# ENG-SF22041-R1-FDR.pdf Markup Summary

RETREAT AT TIMBERIDGE FILING NO. 3
CONSTRUCTION PLANS
PUBLIC STORM SEWER PLAN

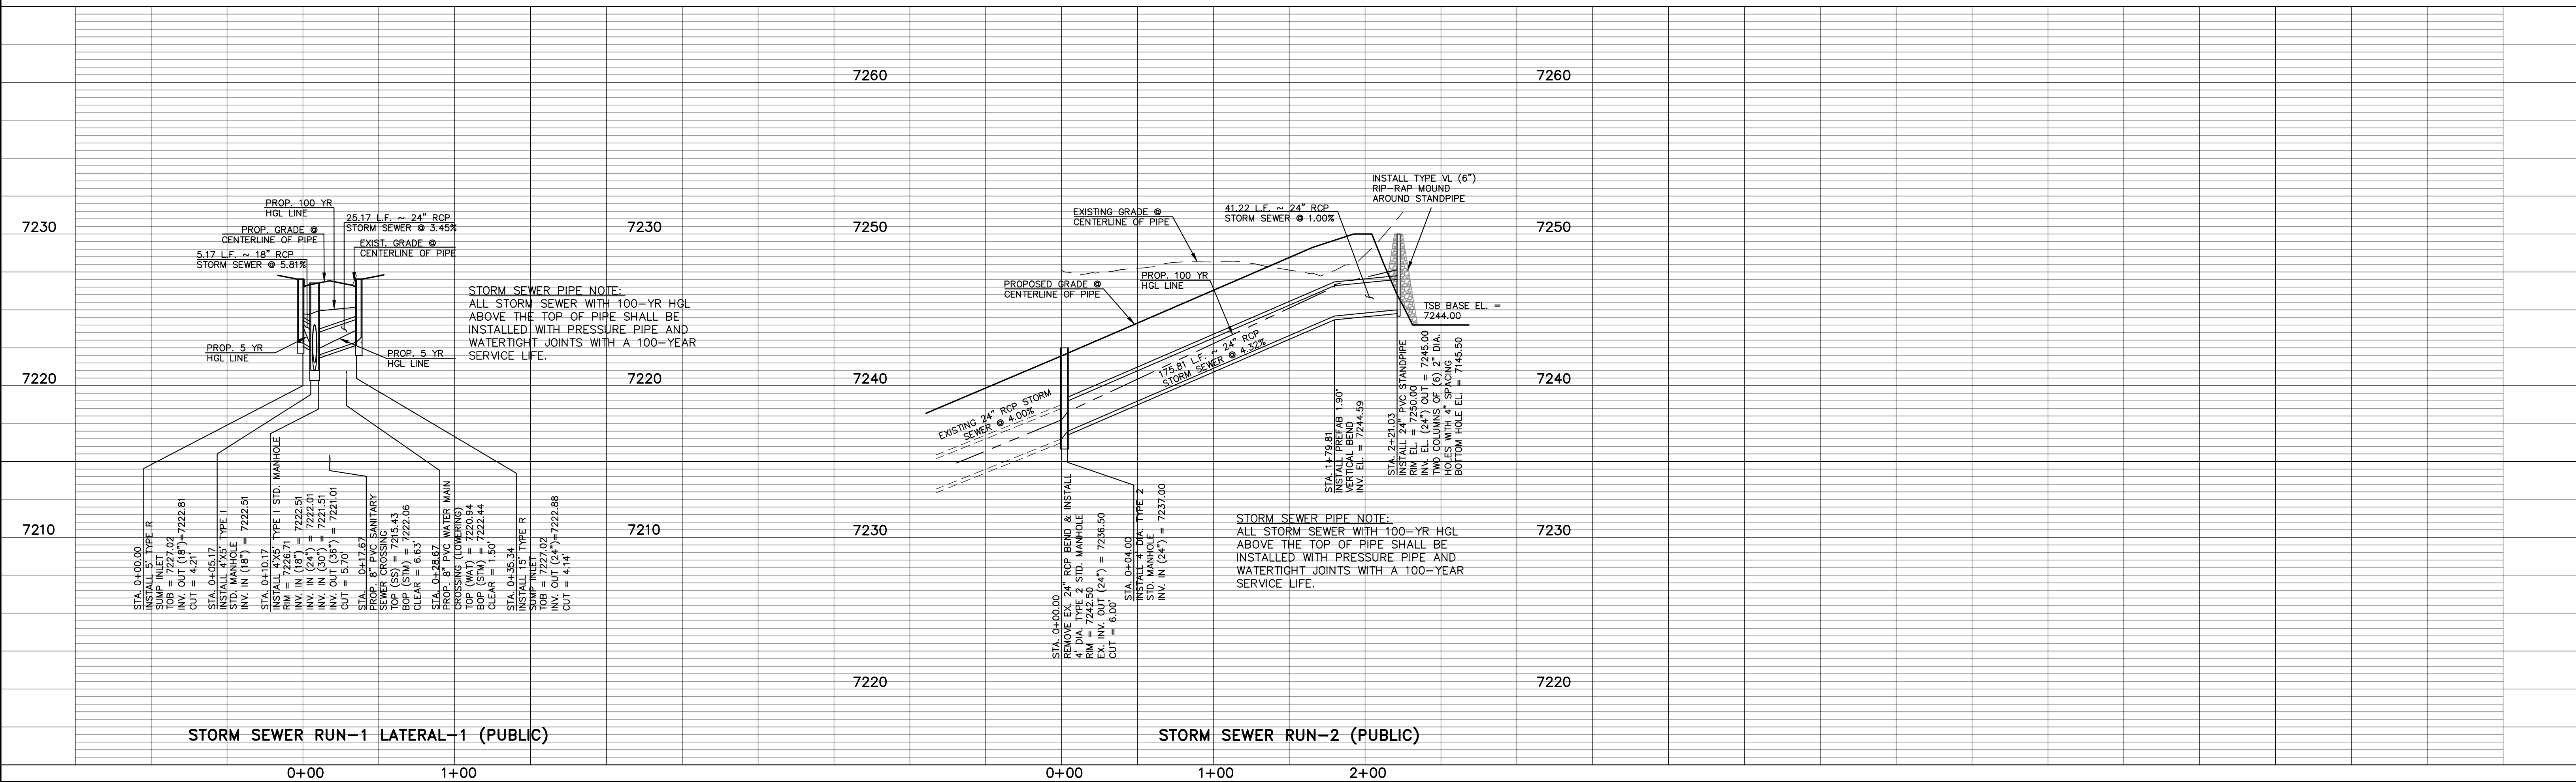
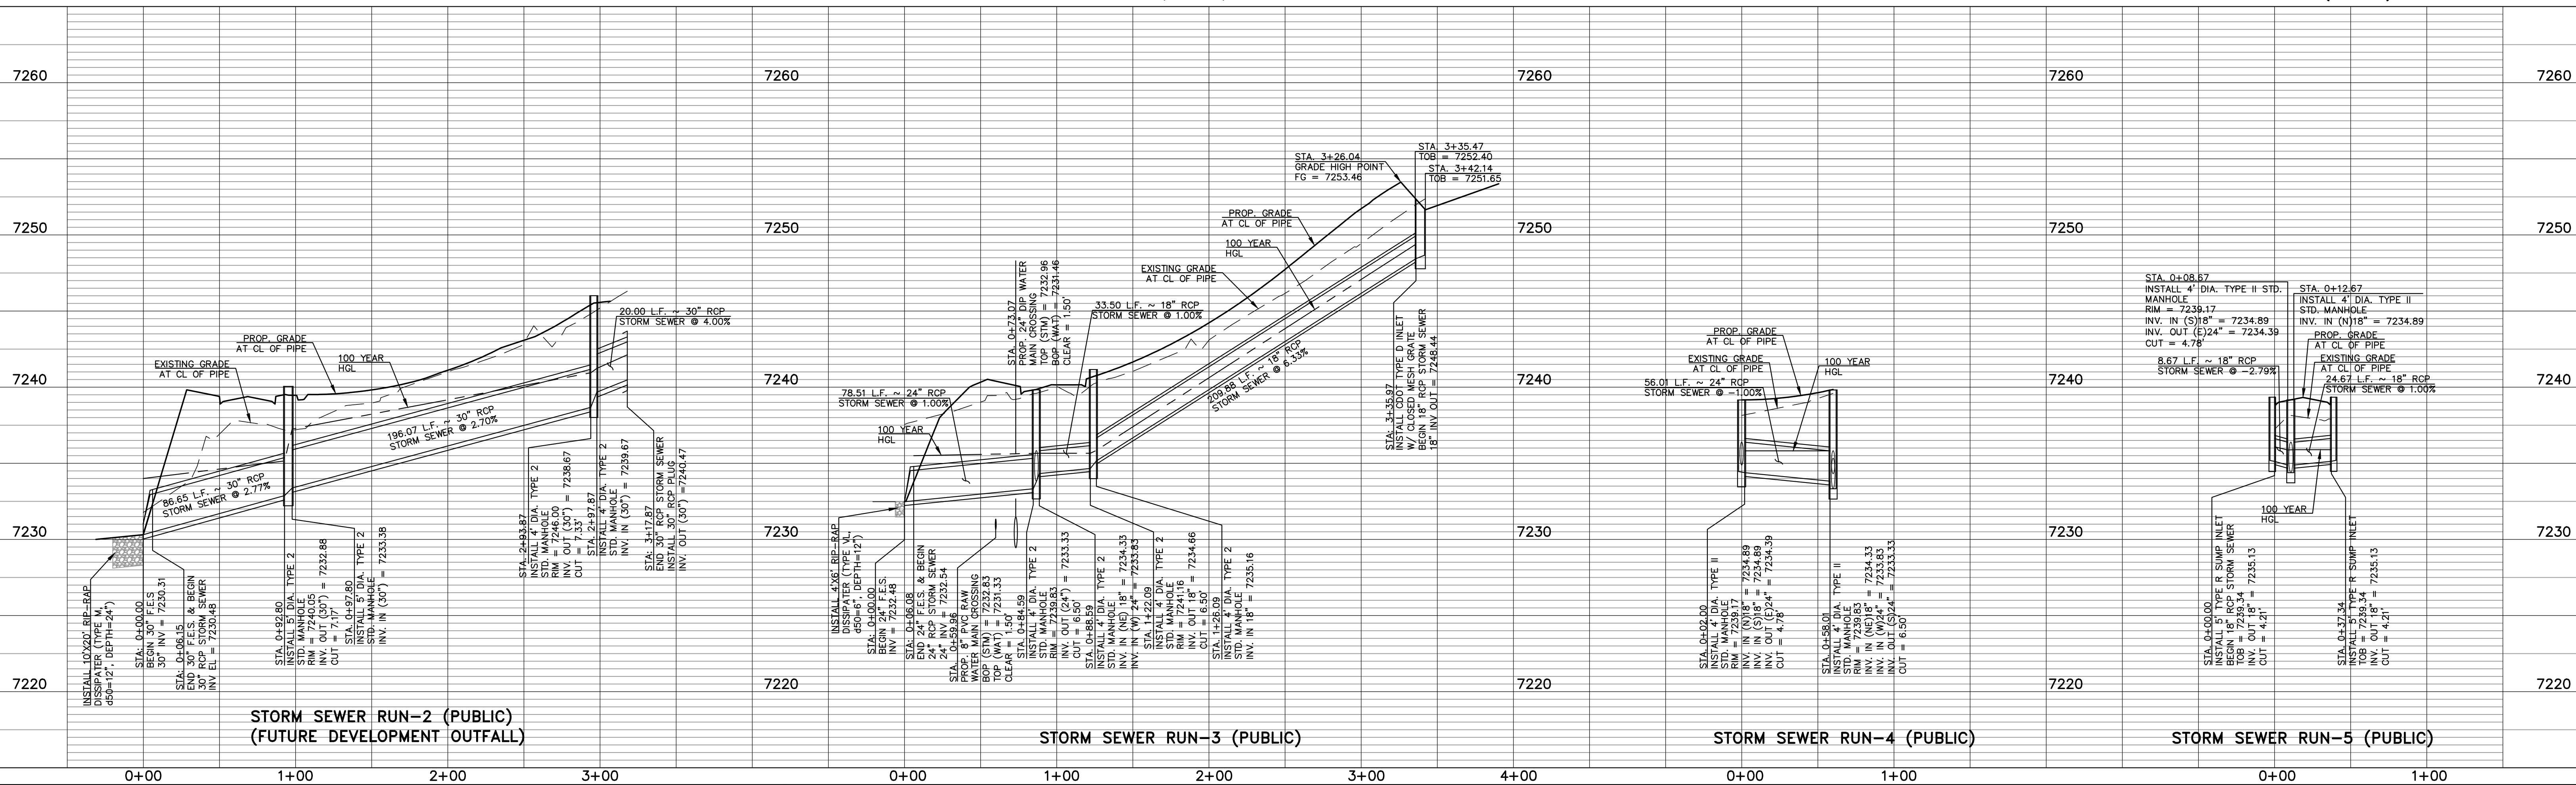
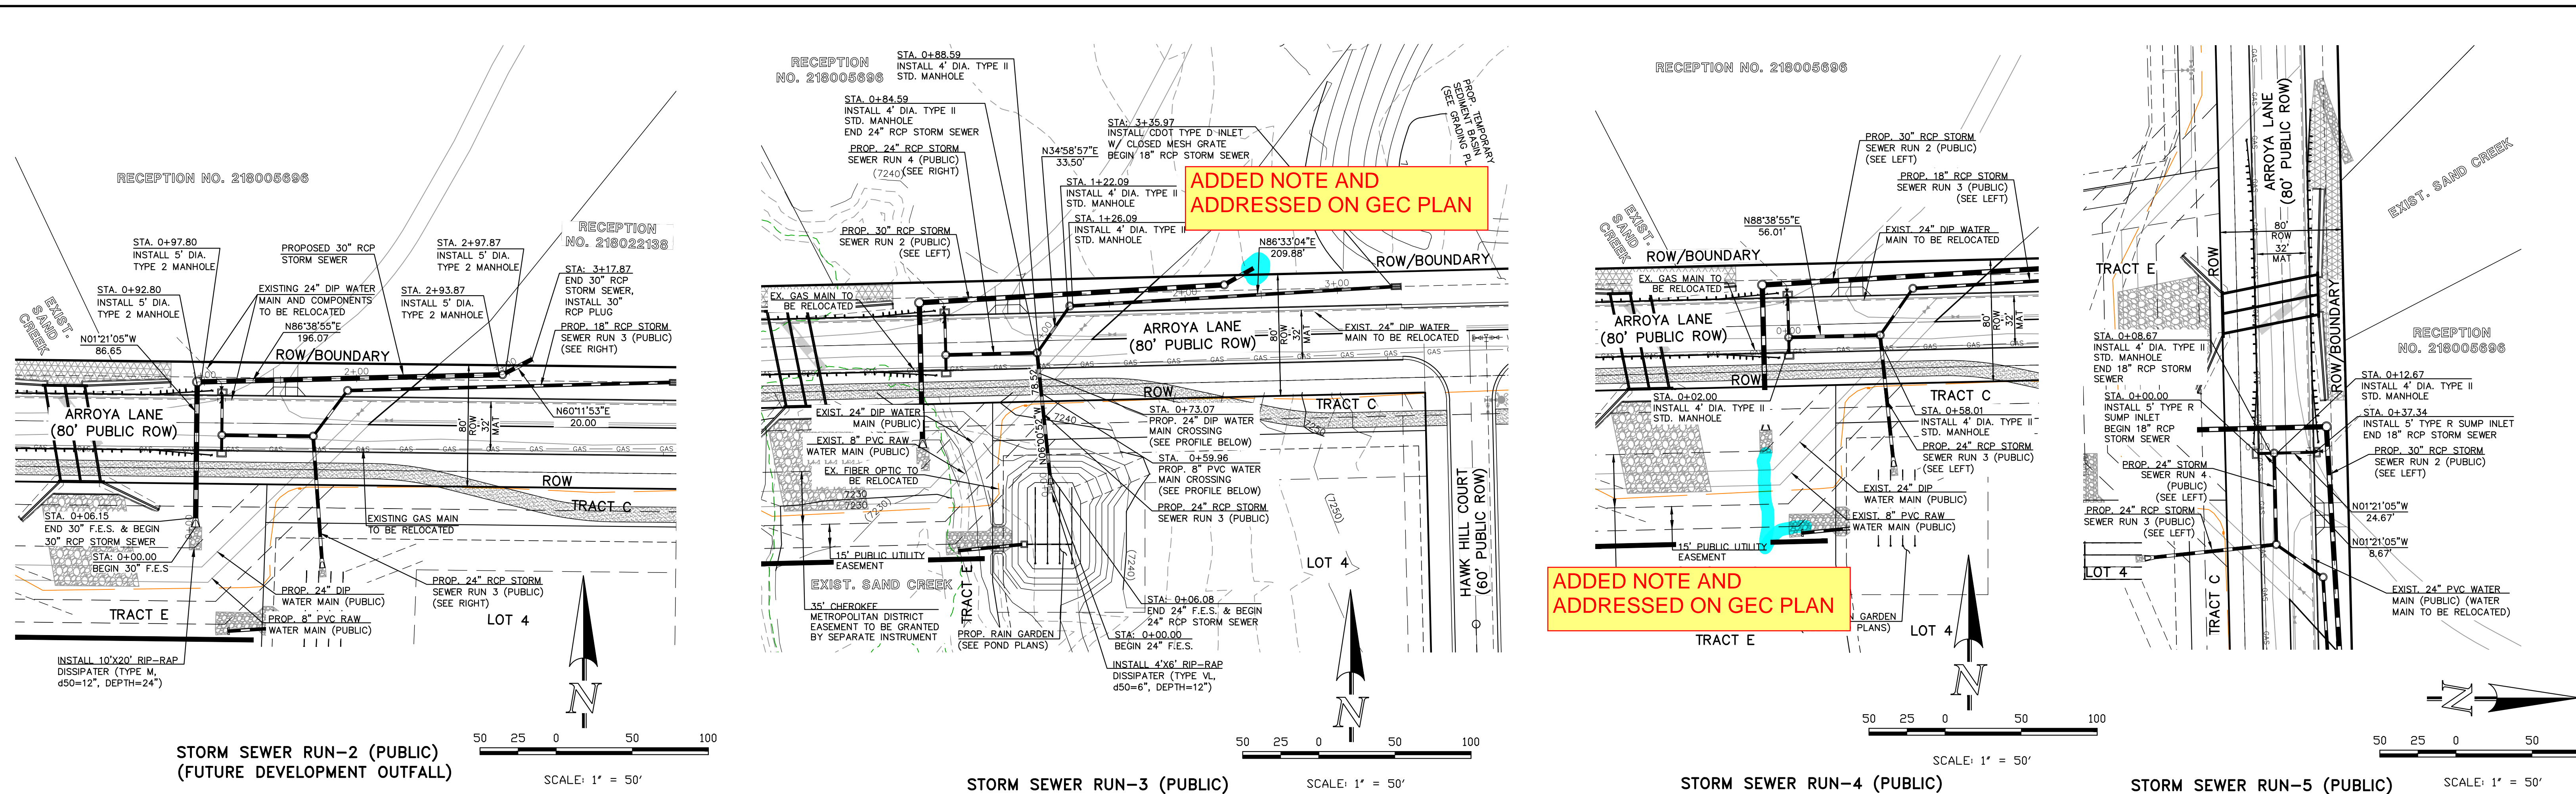
Include existing section of pipe to ensure there's no negative impacts to existing culvert.

-Design/analysis needs to be provided for new pipe @ DP 6 w/connection to existing system

DESIGNED BY | MAW | SCALE DATE 11-22-2022 MAW (H) 1"= 30' | SHEET 18 OF 27 DRAWN BY CHECKED BY (V) 1"= N/A JOB NO. 1185.30

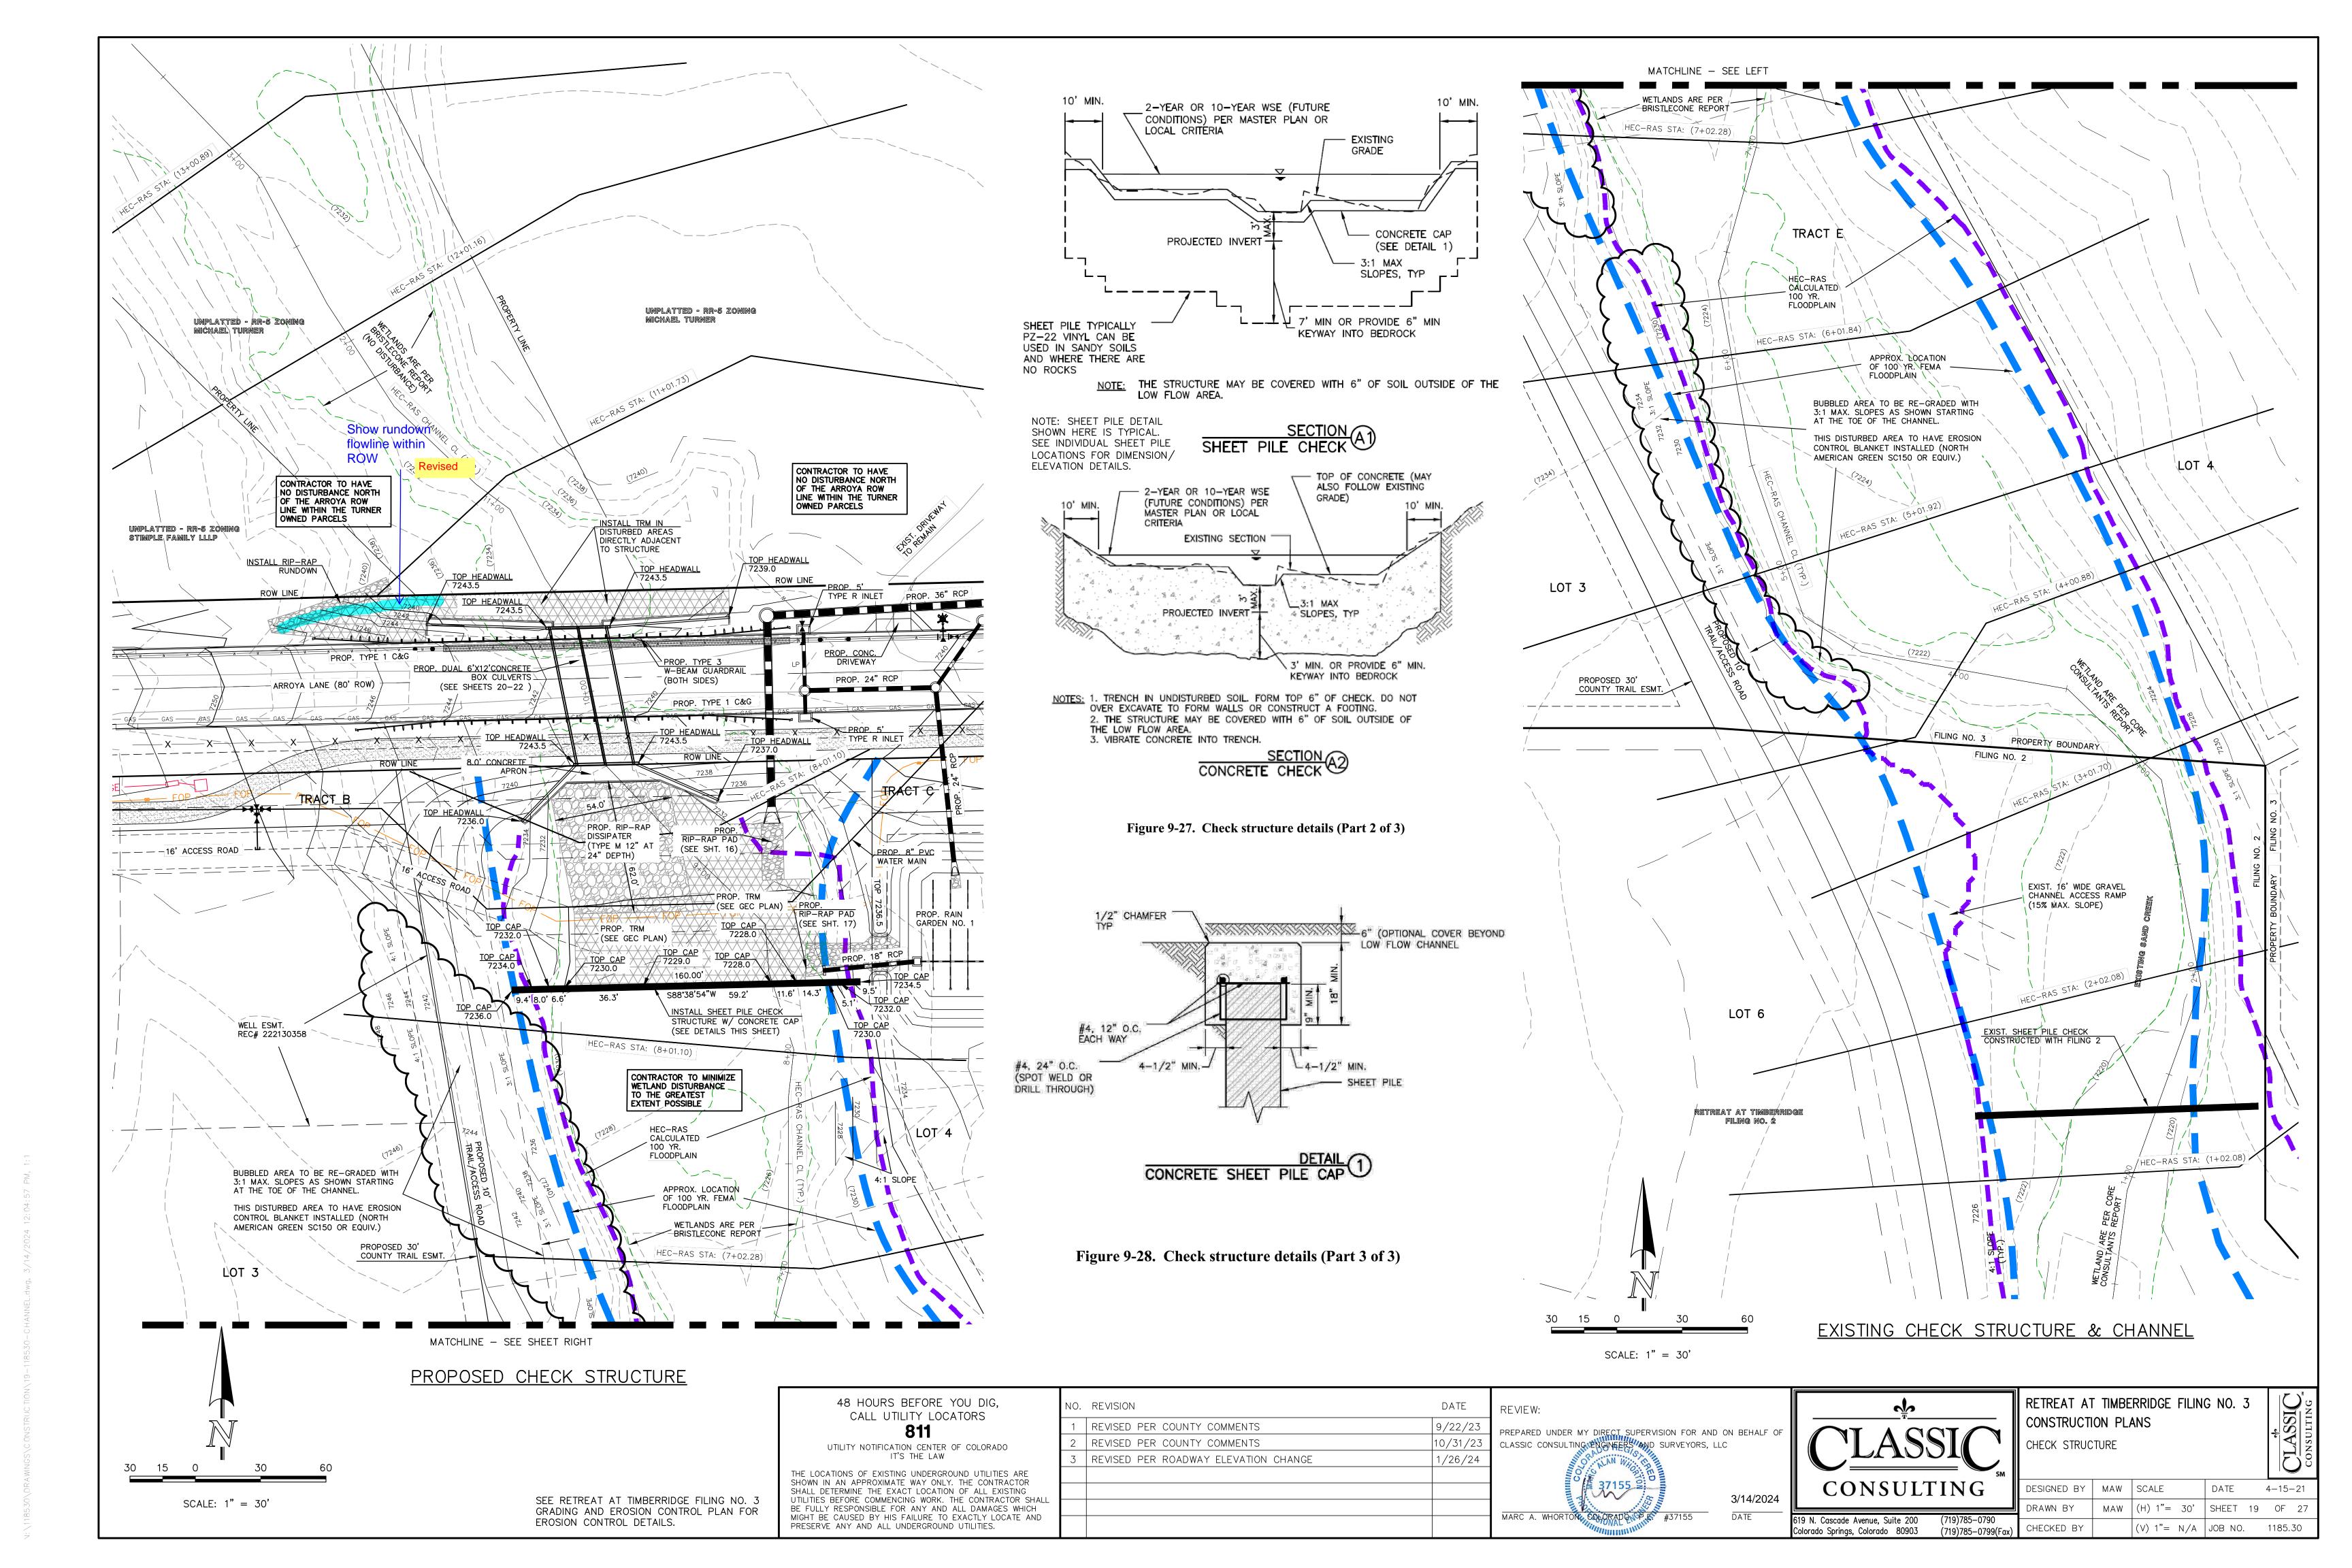
Also provide a cross section showing water and gas line crossings.
